Town & Country Planning Act 1990 (as amended)
Town and Country Planning (Development Management Procedure) (England) Order 2015
Application for Planning Permission

Development Change of use from light industrial (B1Business) to leisure (D2 Assembly & Leisure).
This application may affect the character & appearance of the Angmering
Conservation Area.

Location Seymour and Lisle Ltd The Square Angmering

Drawing
Location Plan

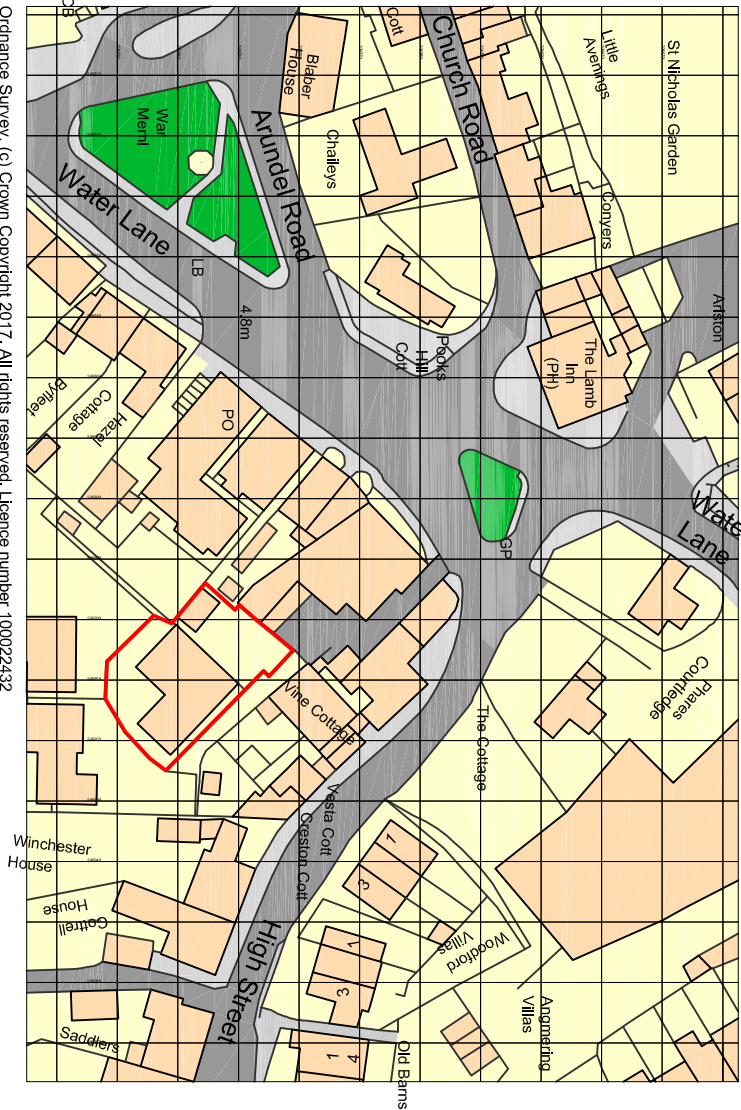
The red edge on the location plan and block plan differ. Please ensure that the red edges on both of these plans match and return accordingly.
